Two storey extension to East, first floor extension to West & new pitched roof on existing garage (resubmission following K/20/15/HH).

The Tower Seaview Avenue Kingston

Thank you for your internet representation made on 16th October 2015 which has been recorded as '**an objection**' with the comments as follows:

Drawing Name
Proposed Elevations

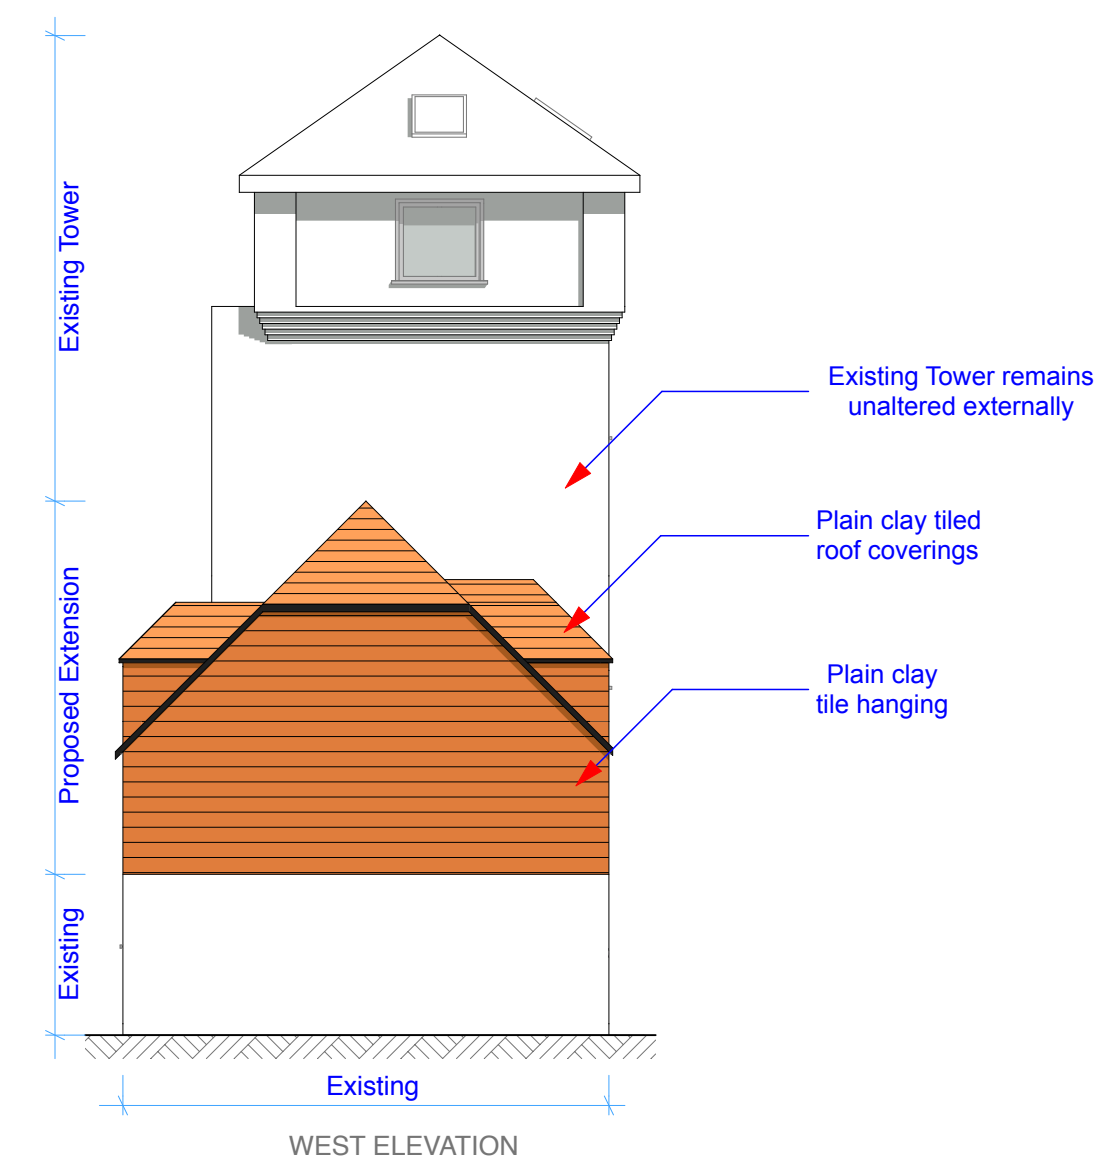
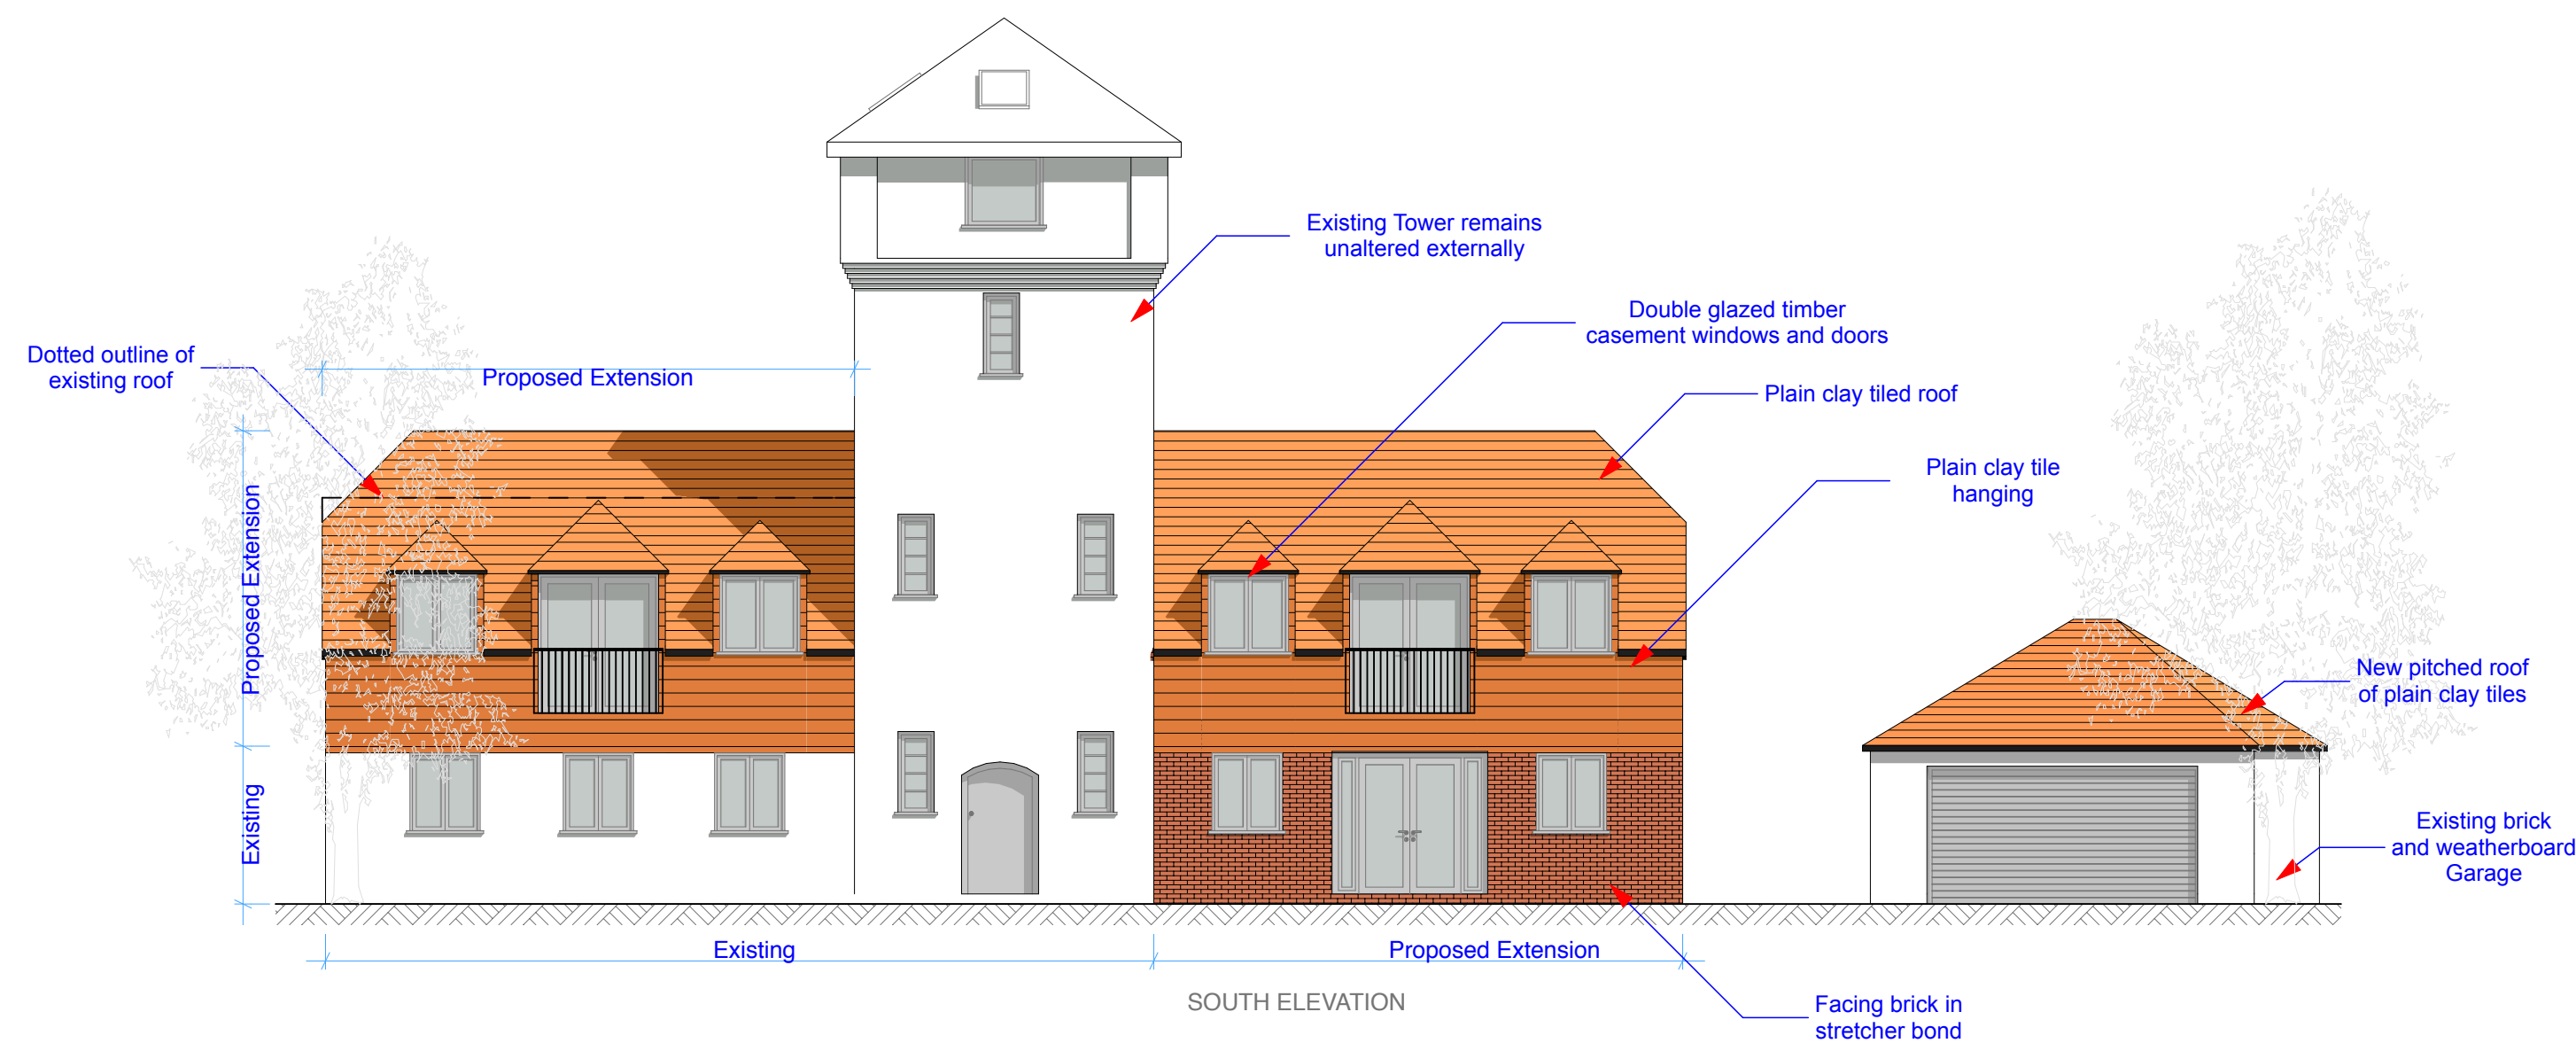
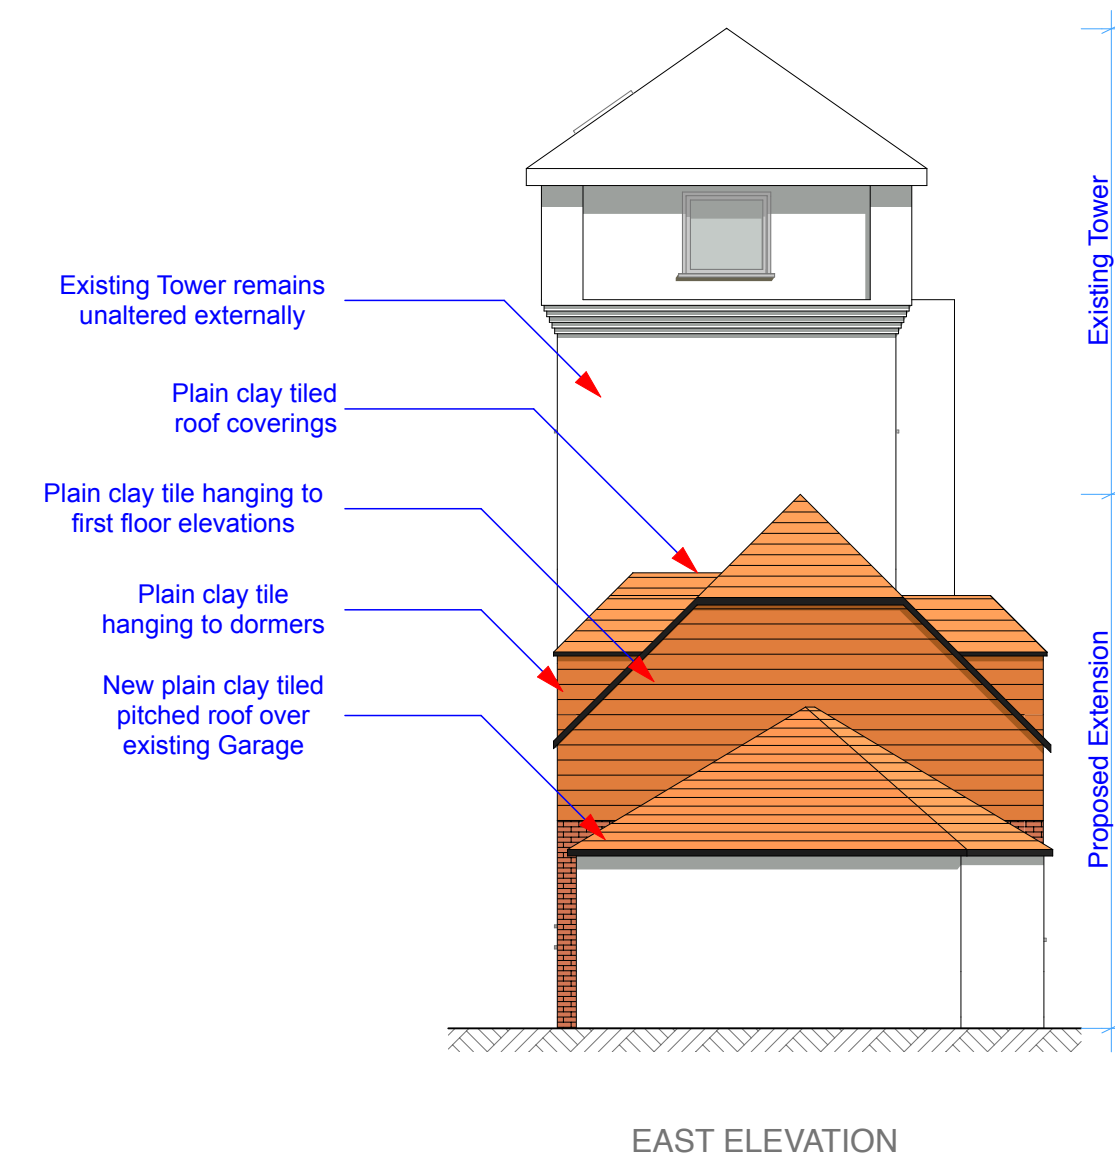
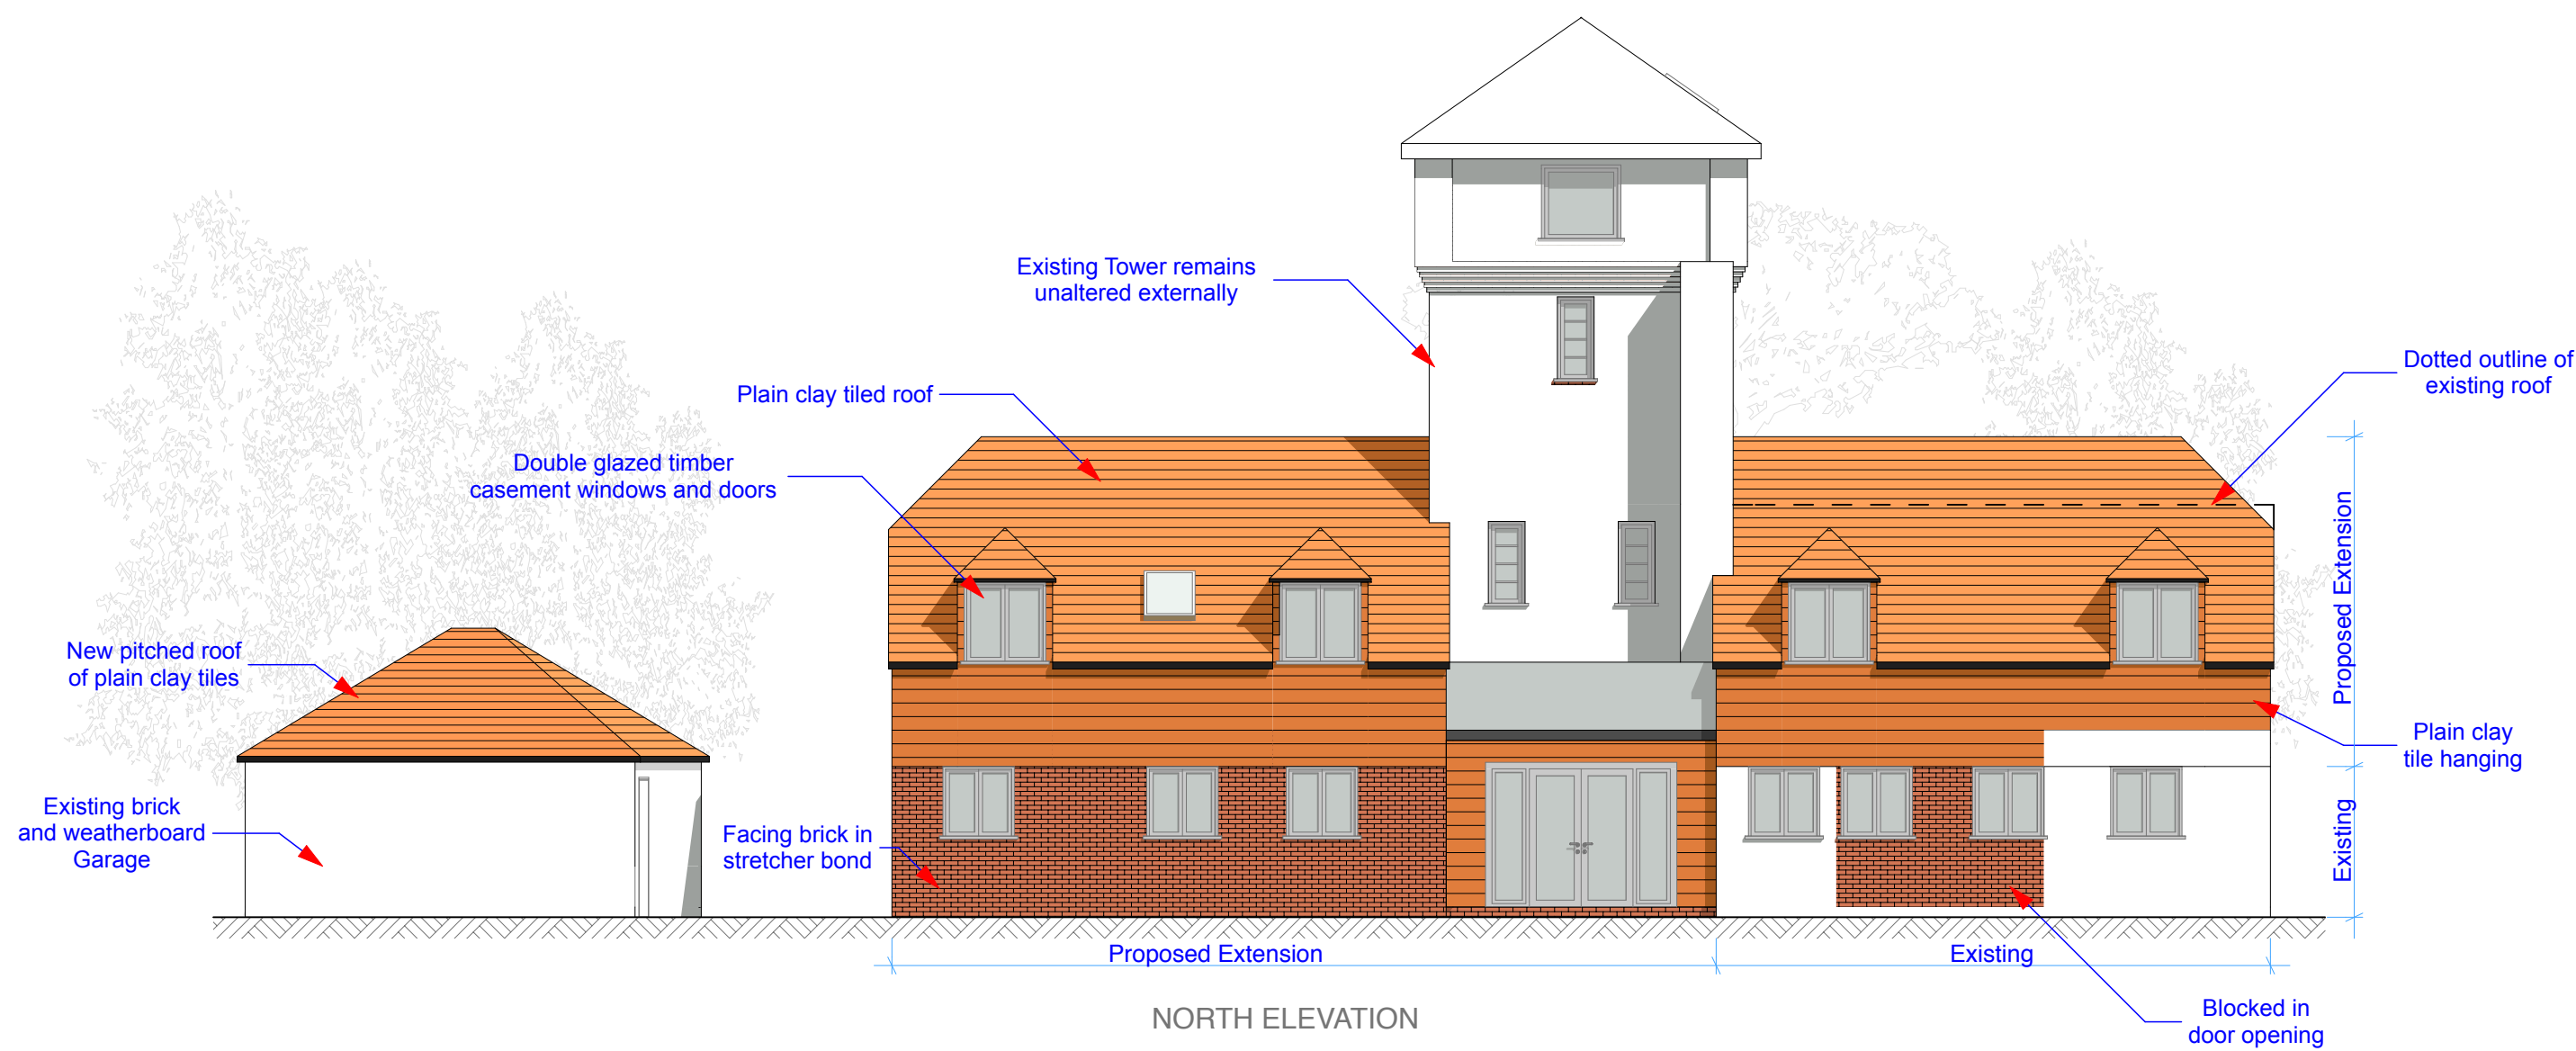
I own Rest Harrow adjacent to The Tower. The proposed plans will create windows overlooking Rest Harrow and in particular looking directly into the master bedroom and bathroom. Kingston Gorse is desired as a location for the seclusion it brings residents. The Tower application will remove this seclusion
